CONSTRUCTION DOCUMENTS MAYBERRY, COLORADO - FILING NO. 2A

MAYBERRY PUD PH 1 - FILING NO. 2A

CONSTRUCTION DOCUMENTS			
JOB NO.	MC22199	ORG. SUBM. DATE	12/22/2022
DWN:	JMP	CHKD:	CJD
NAME

**SITE & UTILITY  
PLAN**

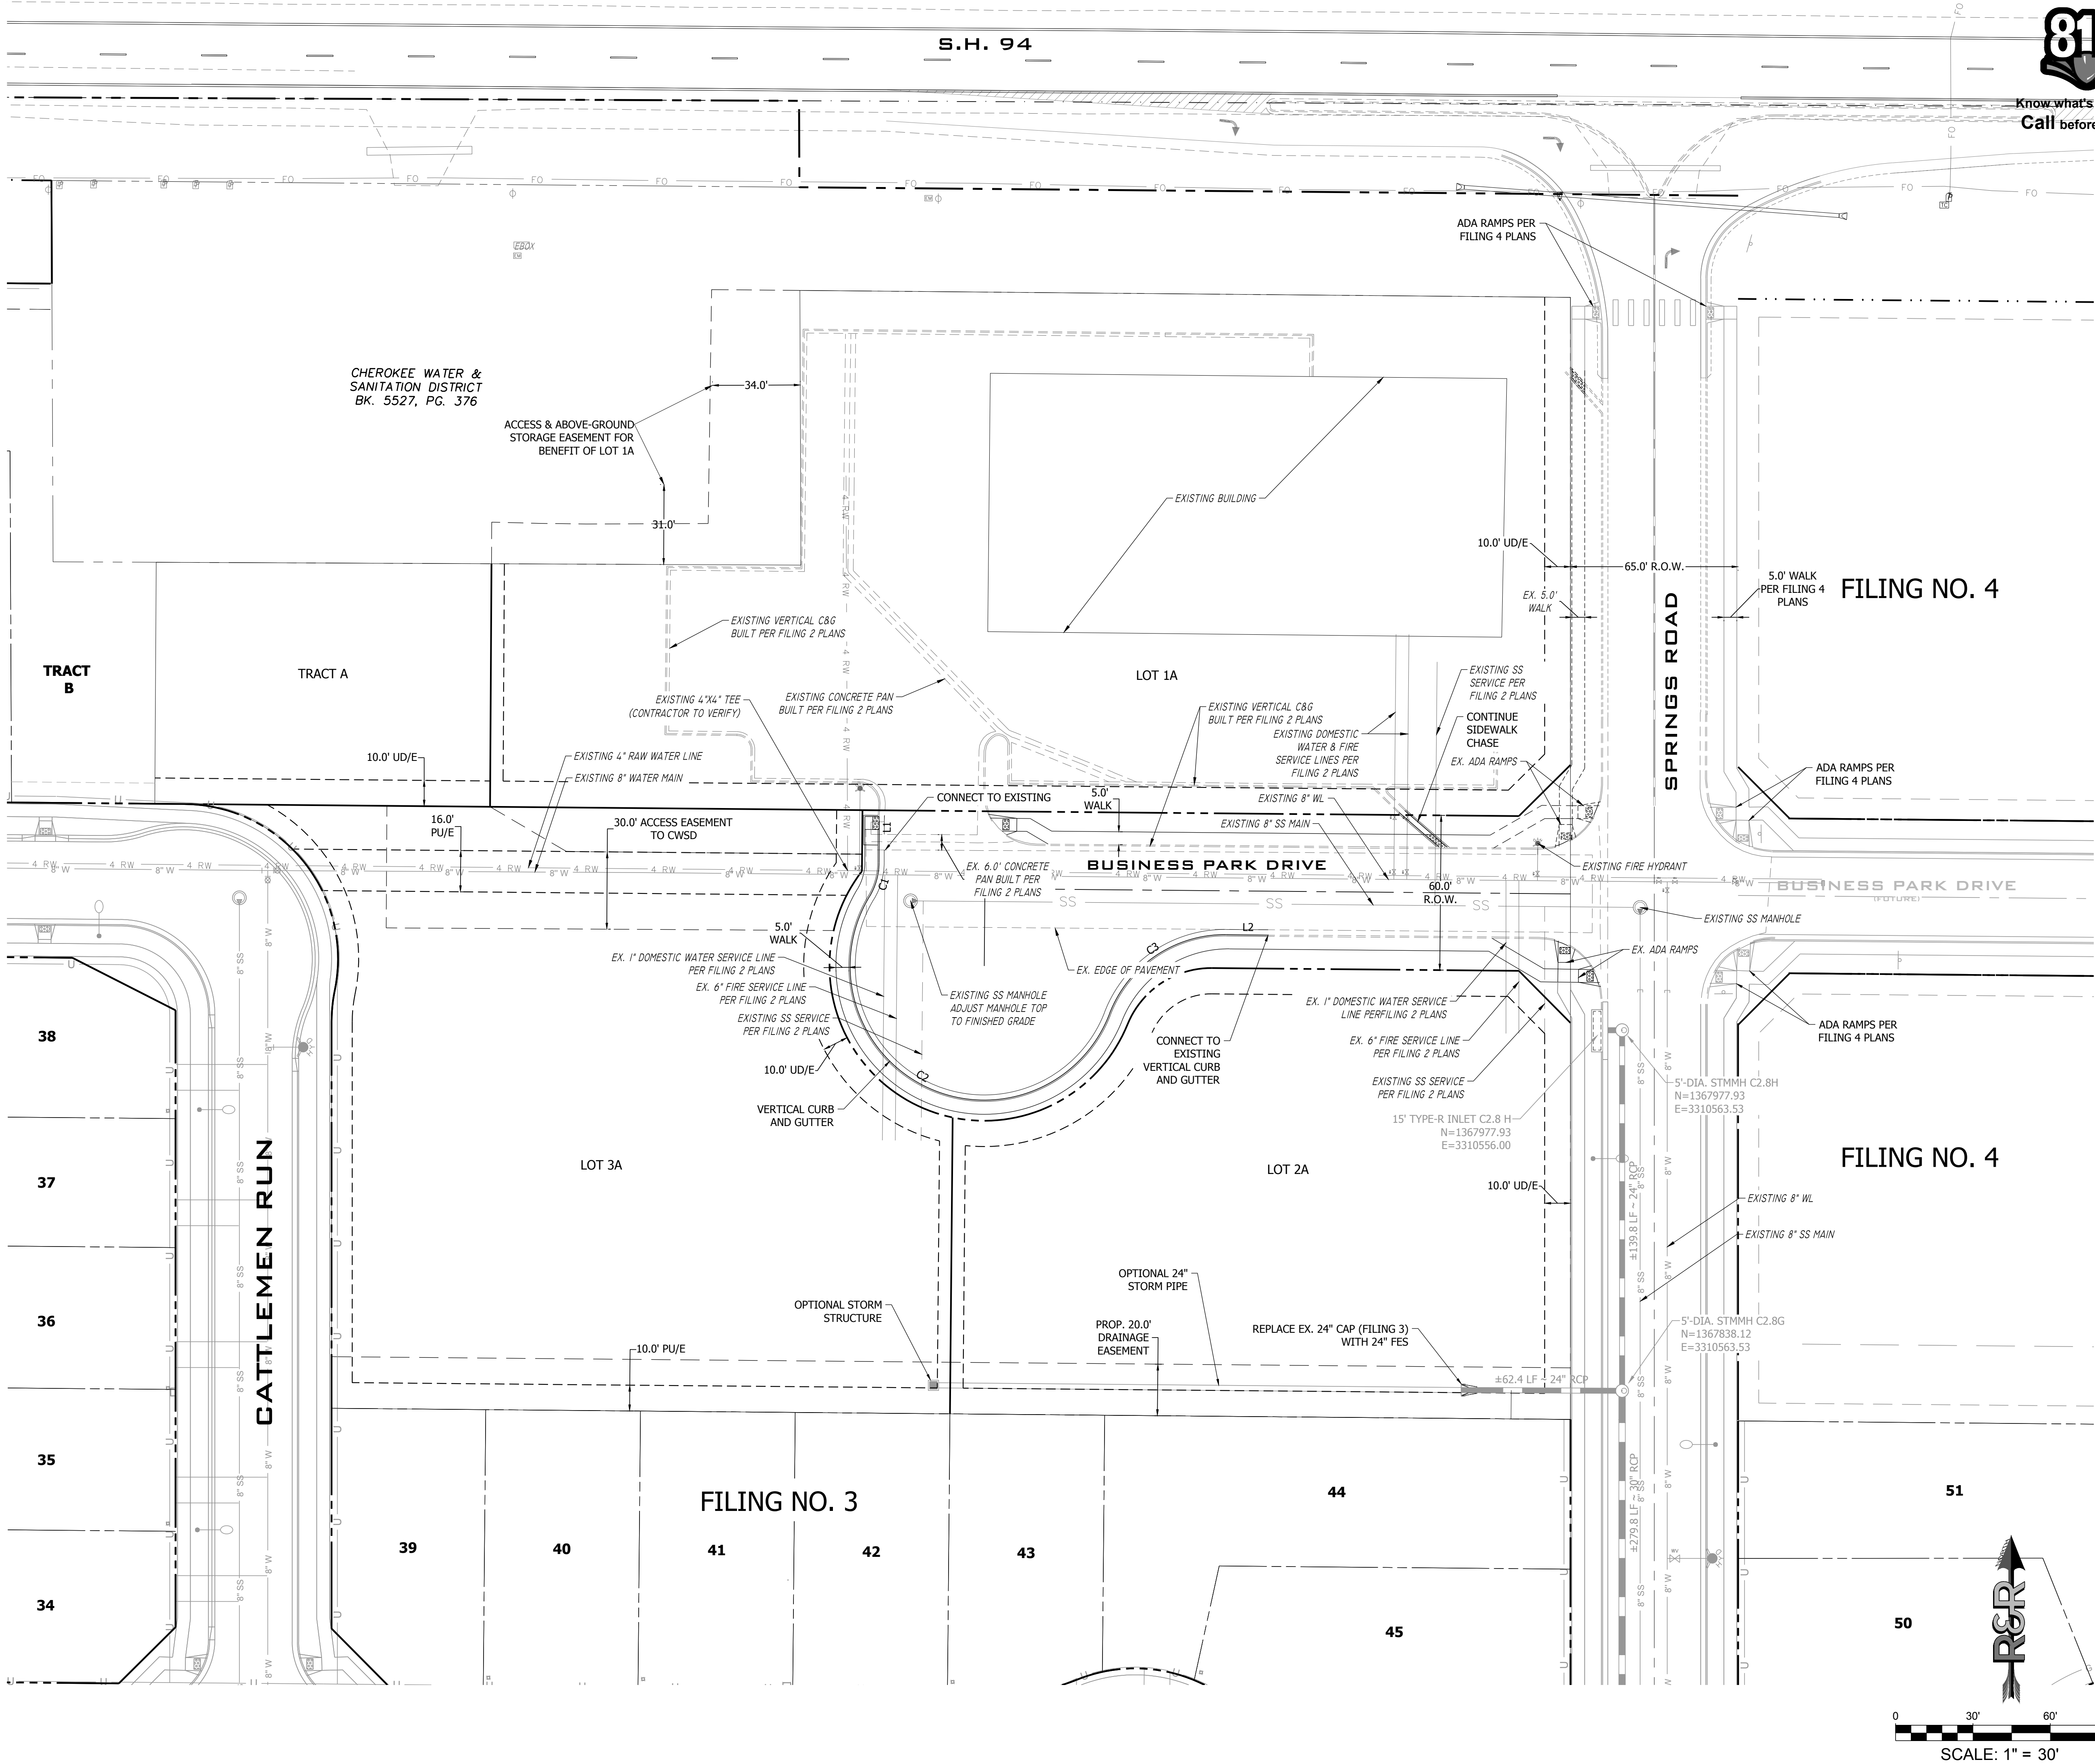
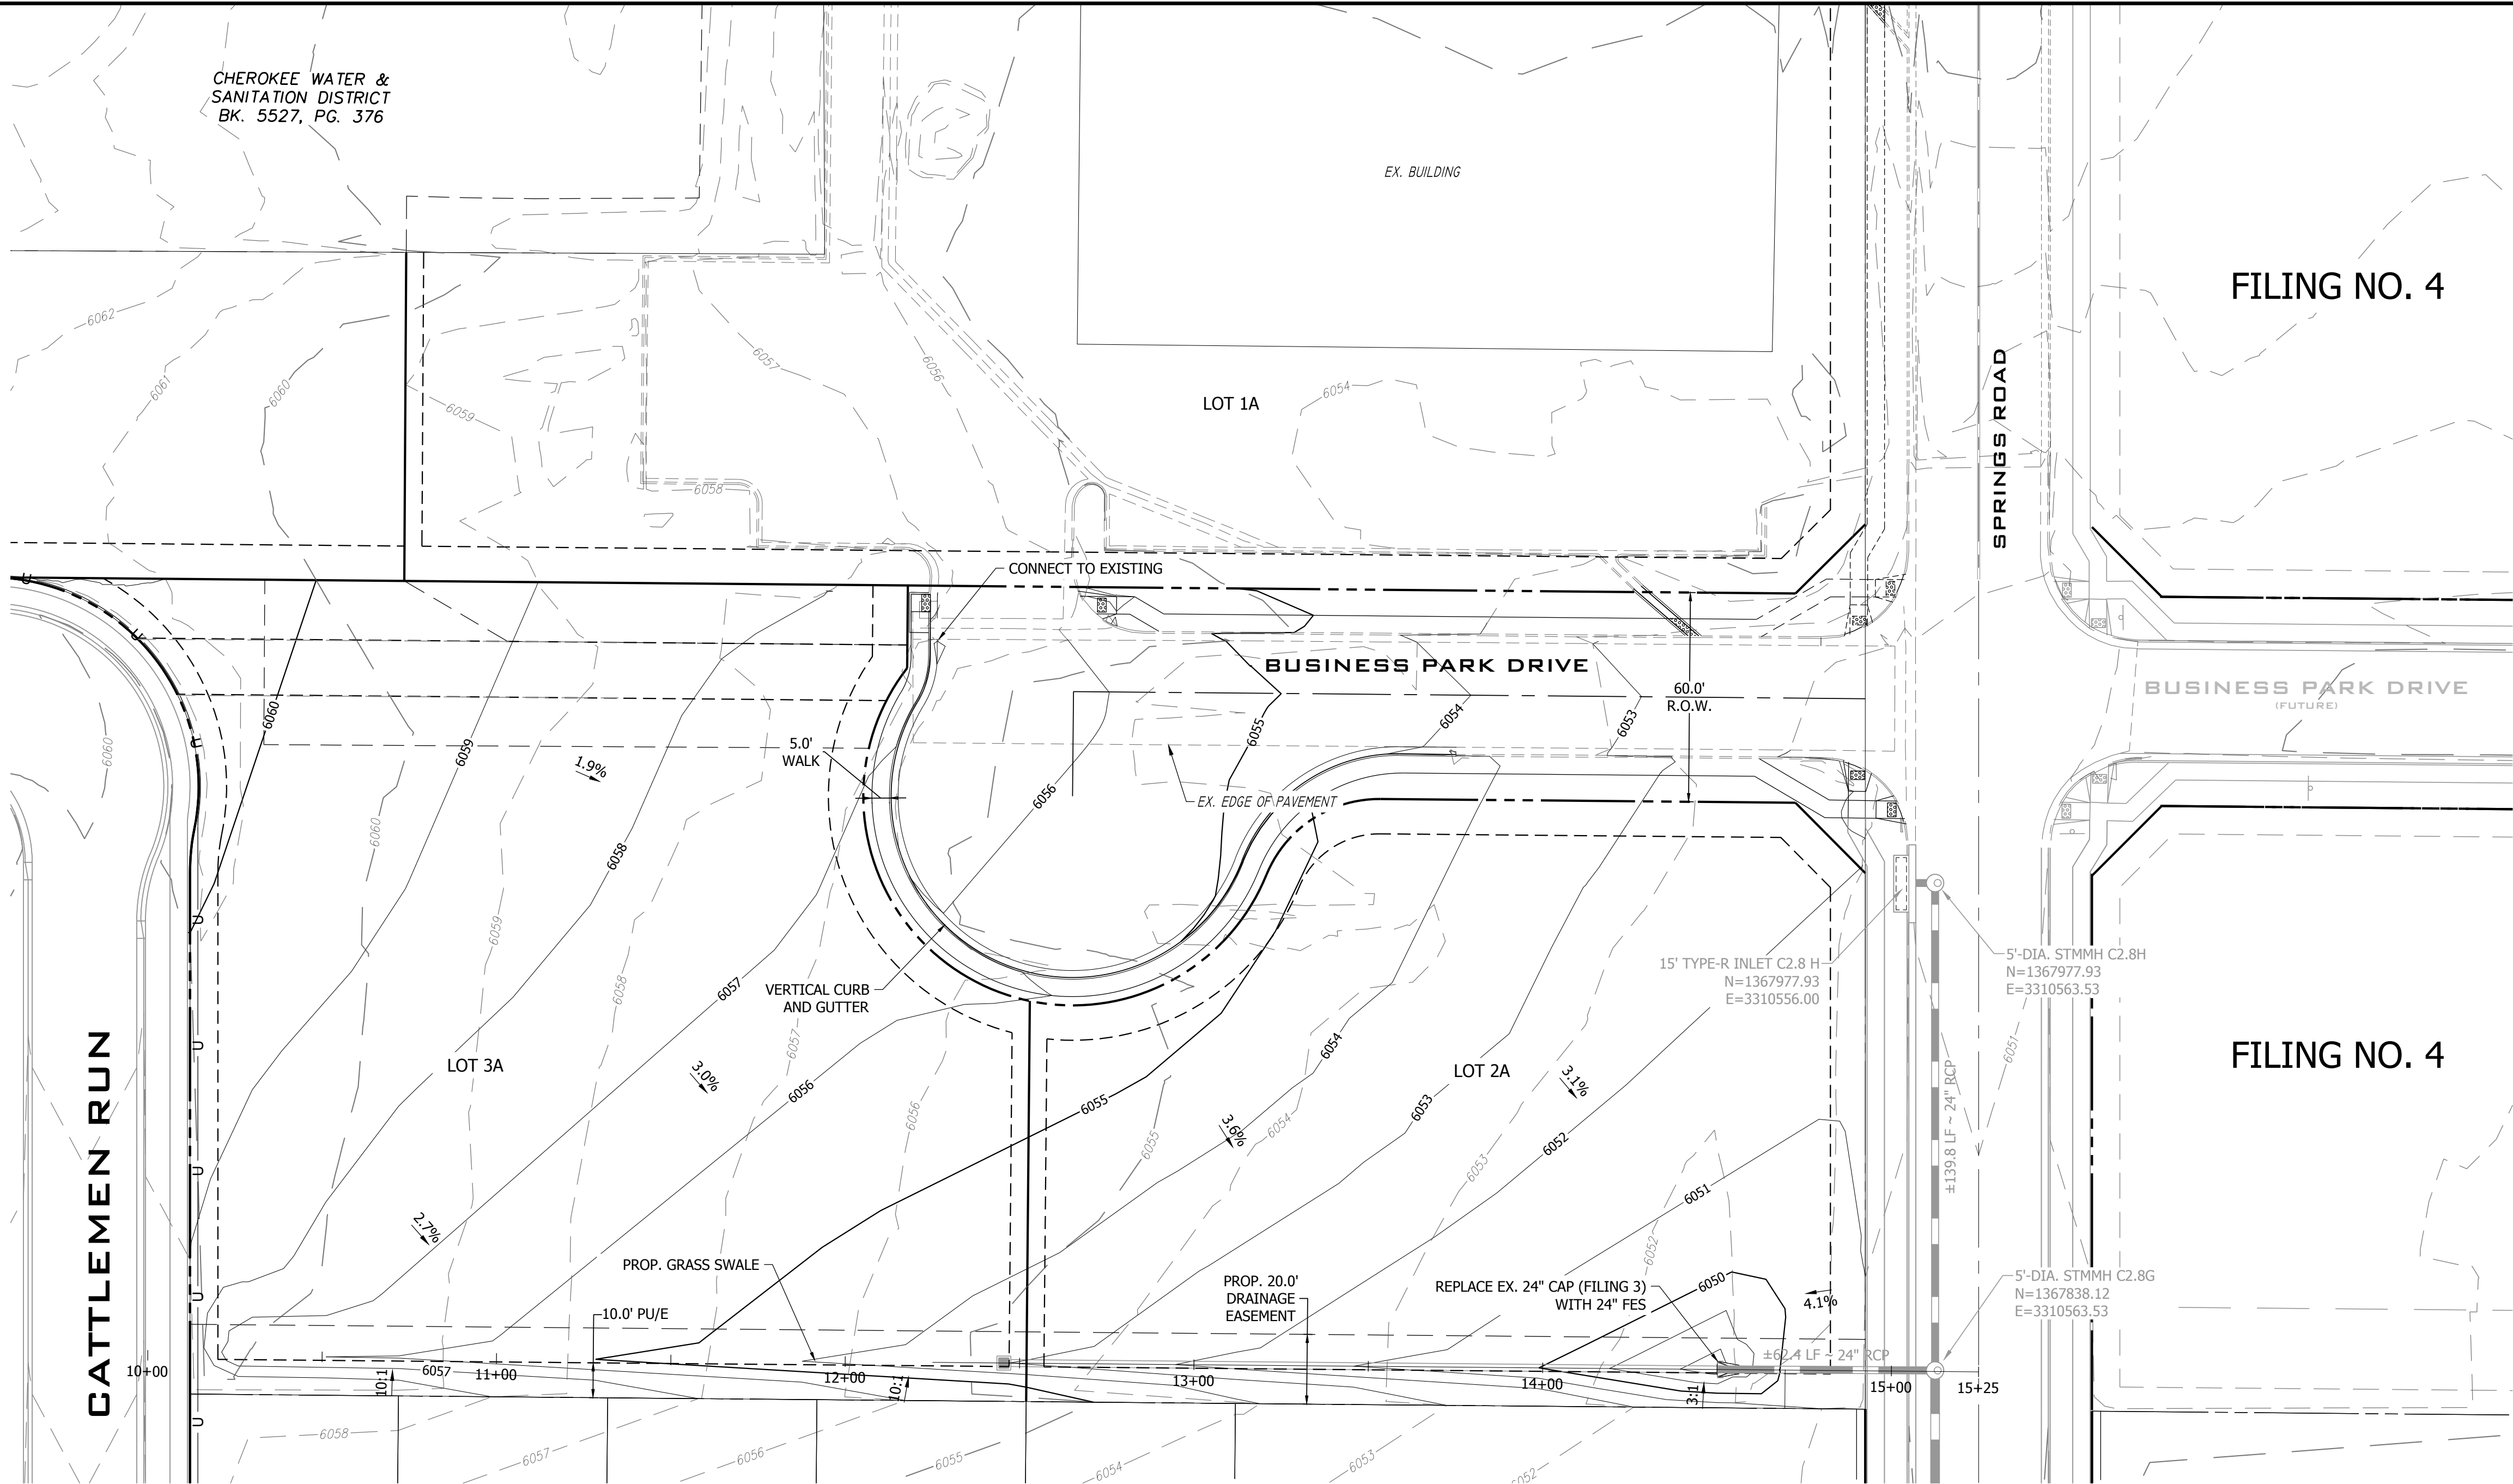
Per the ECM, sidewalk ramps cannot be within a crossspan. Revise to move outside of crossspan.

Understood. ADA ramps have been slightly moved north to get out of the limits of the crossspan.

OPTIONAL  
GRADING &  
DRAINAGE PLAN

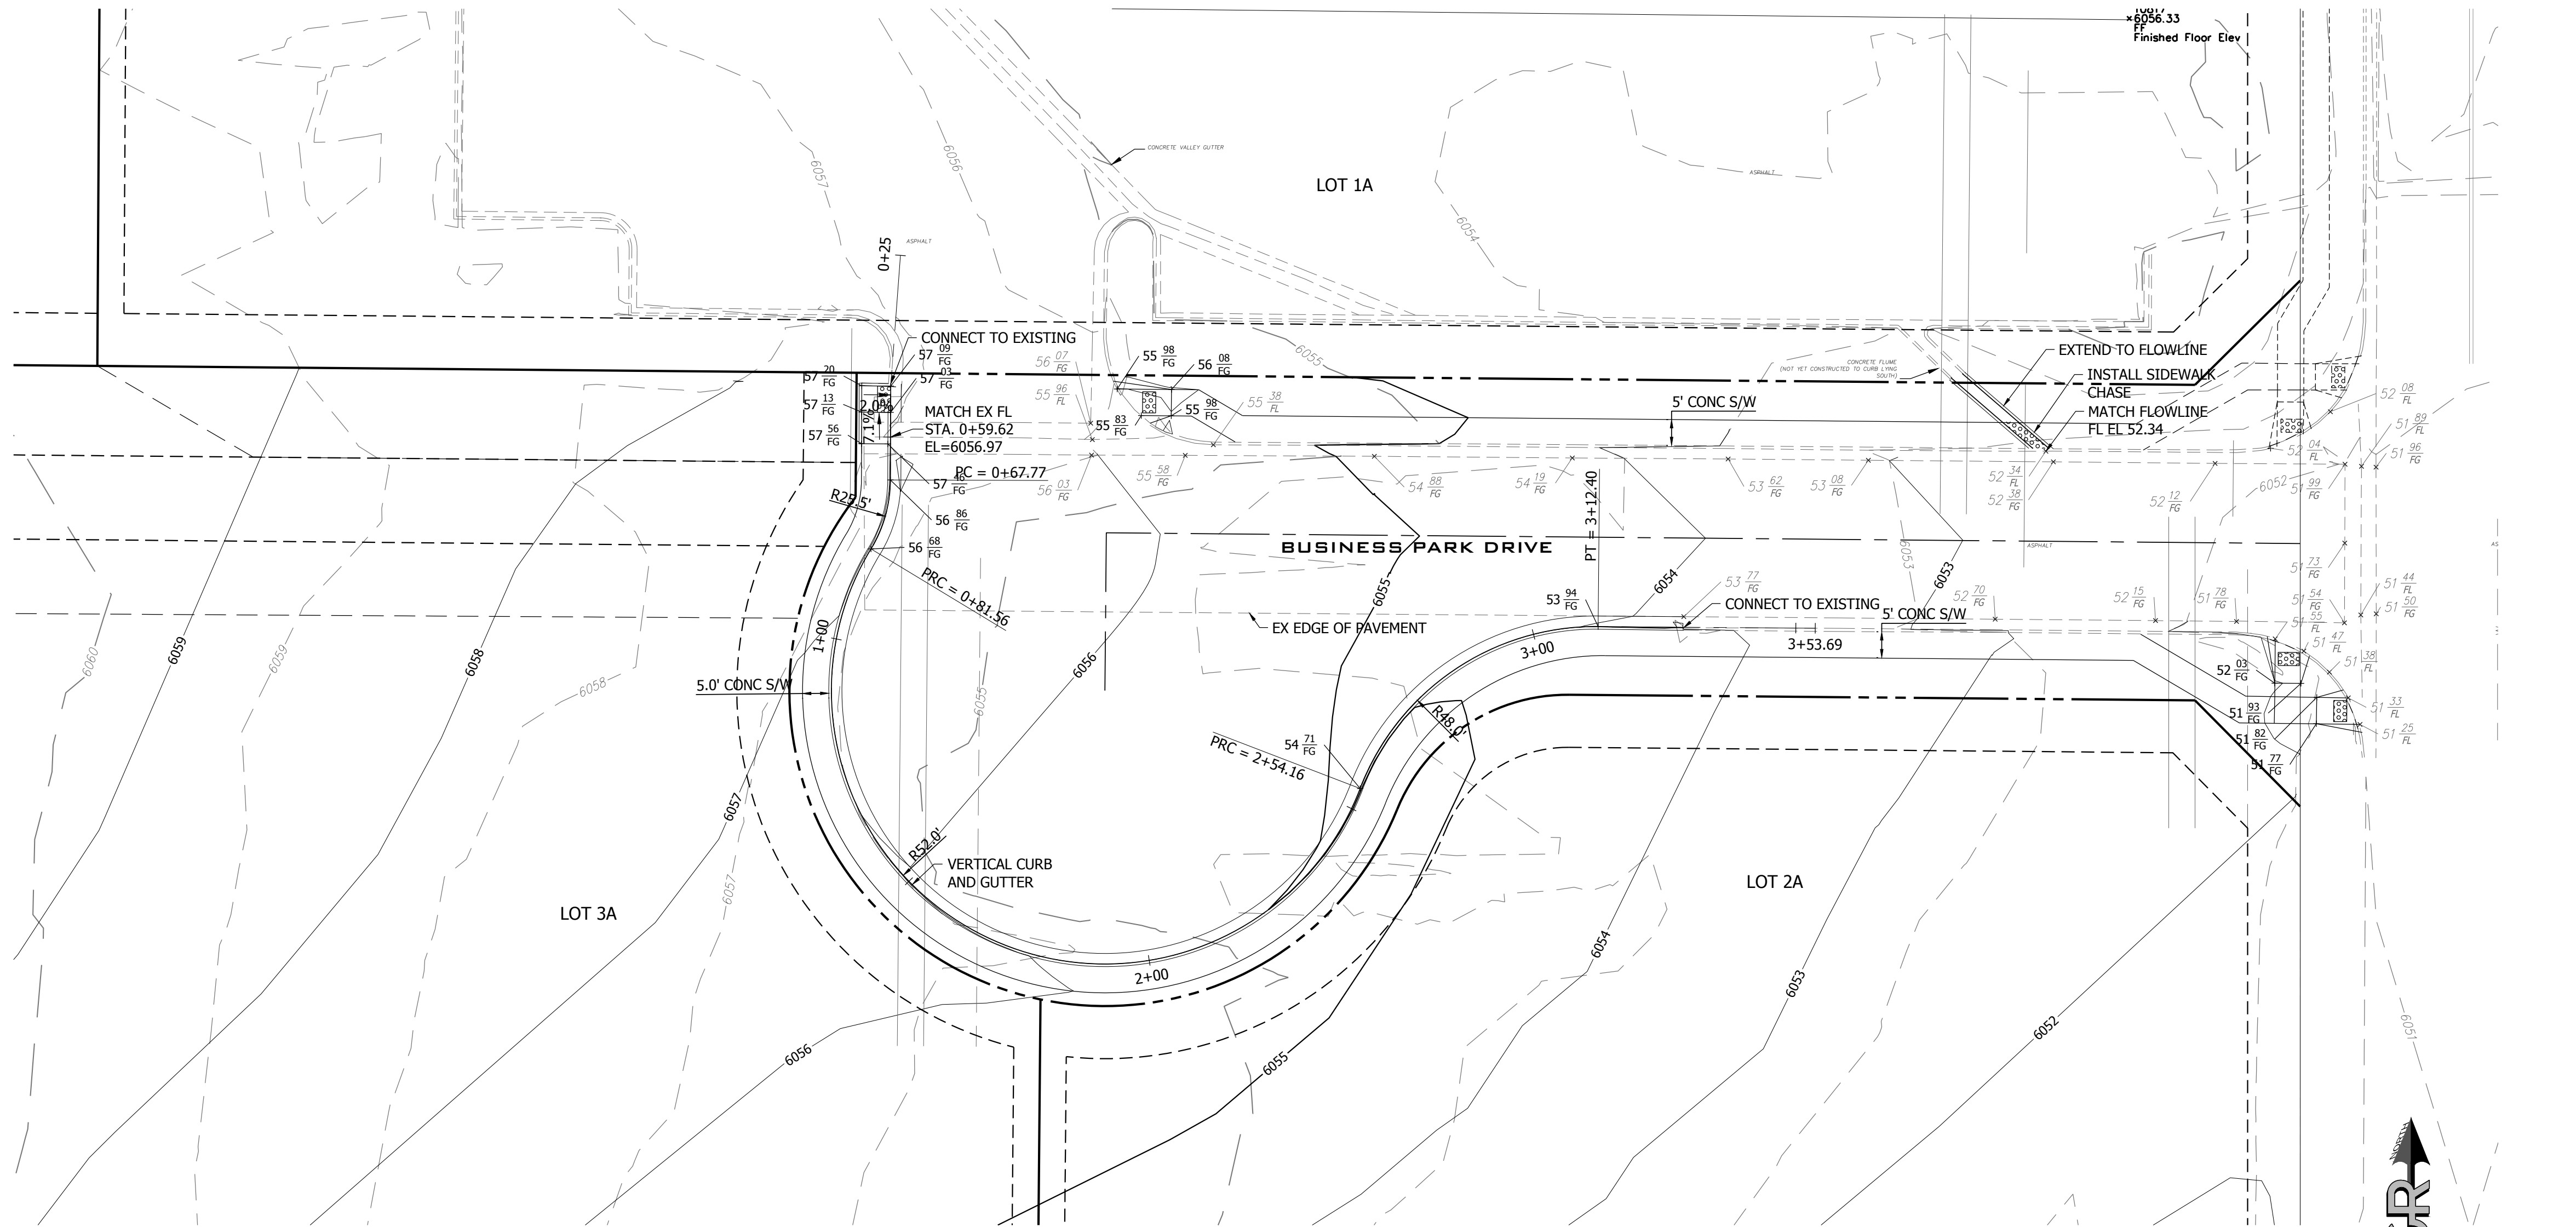
Per ECM 4.3.6.A.2, storm pipes should not be placed less than 5 feet from the ground line. Revise or submit a deviation request for consideration if there is a hardship.

ECM 4.3.6.A.2 references the minimum depth for a sanitary sewer line. ECM 4.3.6.A.3 references the minimum depth for a storm line to be 2' under paved areas. The current depth meets that requirement and no deviation request is needed.
